Address: 1 Stainecross Avenue Huddersfield HD4 5HZ

Application number: 2024/92983	
What is the application for?:	Erection of detached garage (part retrospective)
Address of the site or building:	3, Stainecross Avenue, Crosland Moor, Huddersfield, HD4 5HZ
Postcode:	HD4 5HZ

PROPOSED GARAGE PLAN.
SCALE 1:50.

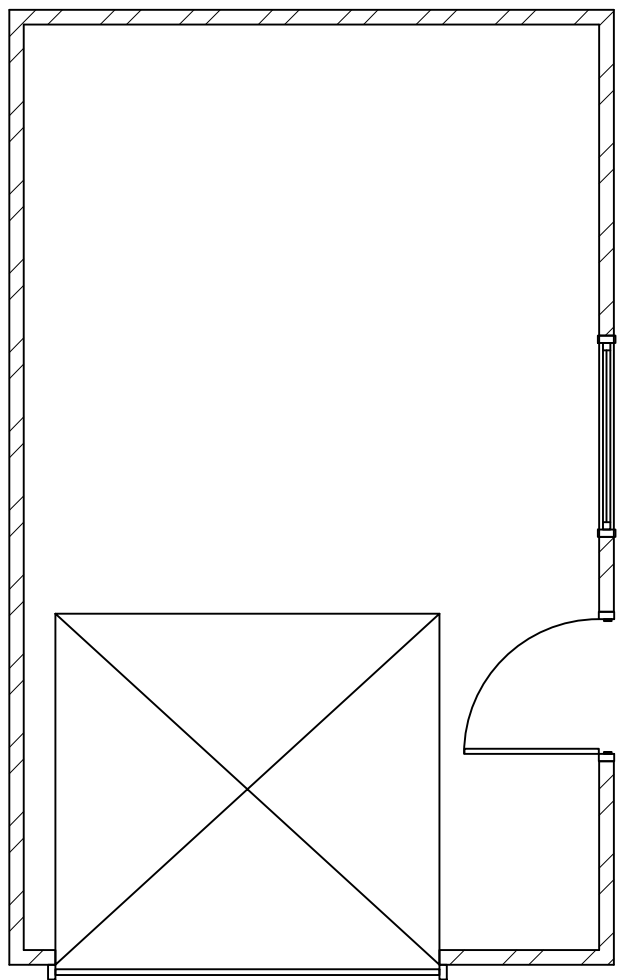
I am also very concerned that there is no intention of using this building as a garage, rather a living space. I do not believe that a garage would consist of a side door, double window and large patio doors. A garage would also not be so large and built so high, it is almost the same height as the recently constructed extension on the main property. I am extremely concerned for anyone who would be entering or living in this space as the building is completely unsafe and is an accident waiting to happen for someone who is either in the garden or within the building itself.

PROPOSED FRONT ELEVATION.
SCALE 1:100.

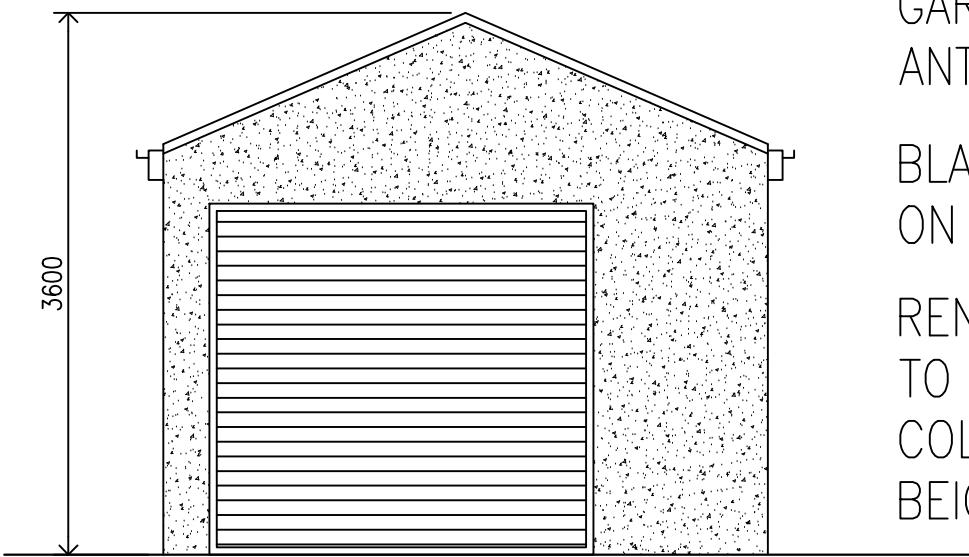
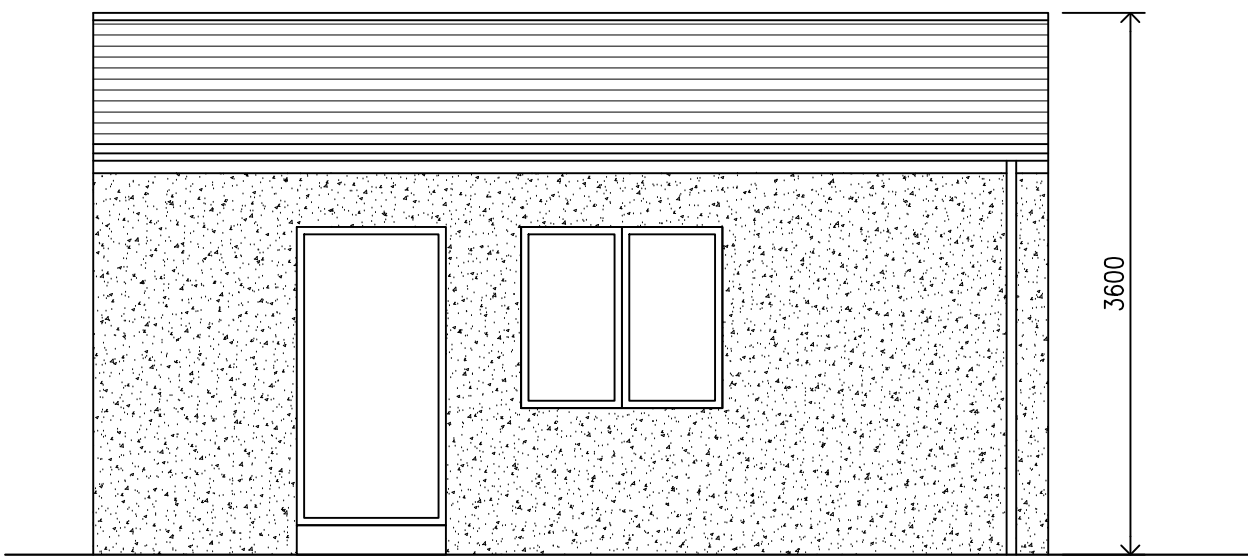
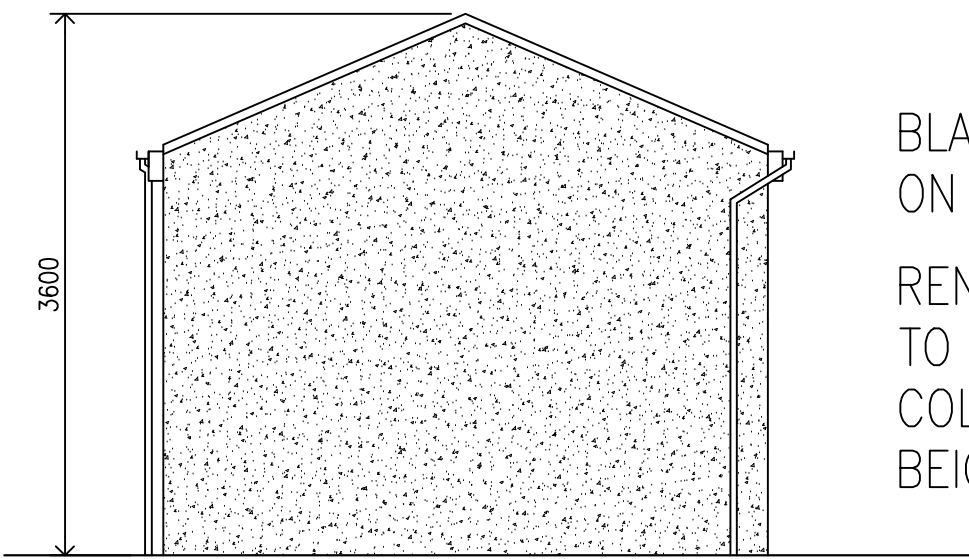
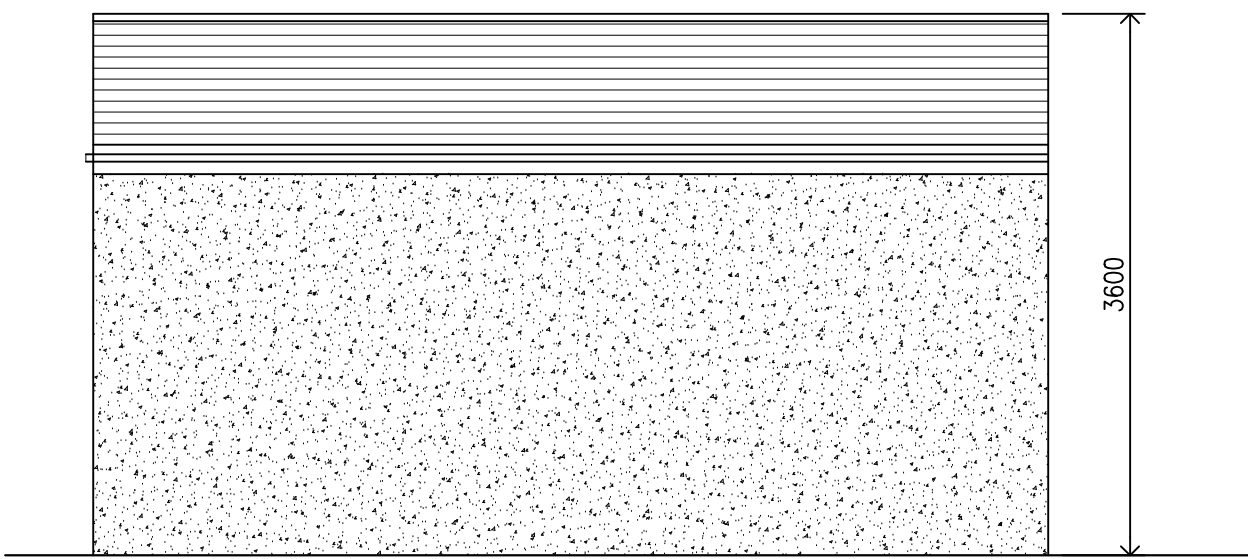
The building consists of a standard garage door, side door, double window and large set of patio doors. These doors and the window do not appear to have been safely fitted to the building with gaps around all of them and very poor grouting. The patio doors have a girder above them which is not level and appears to be fixed within the poor brickwork in a very unsafe manner.
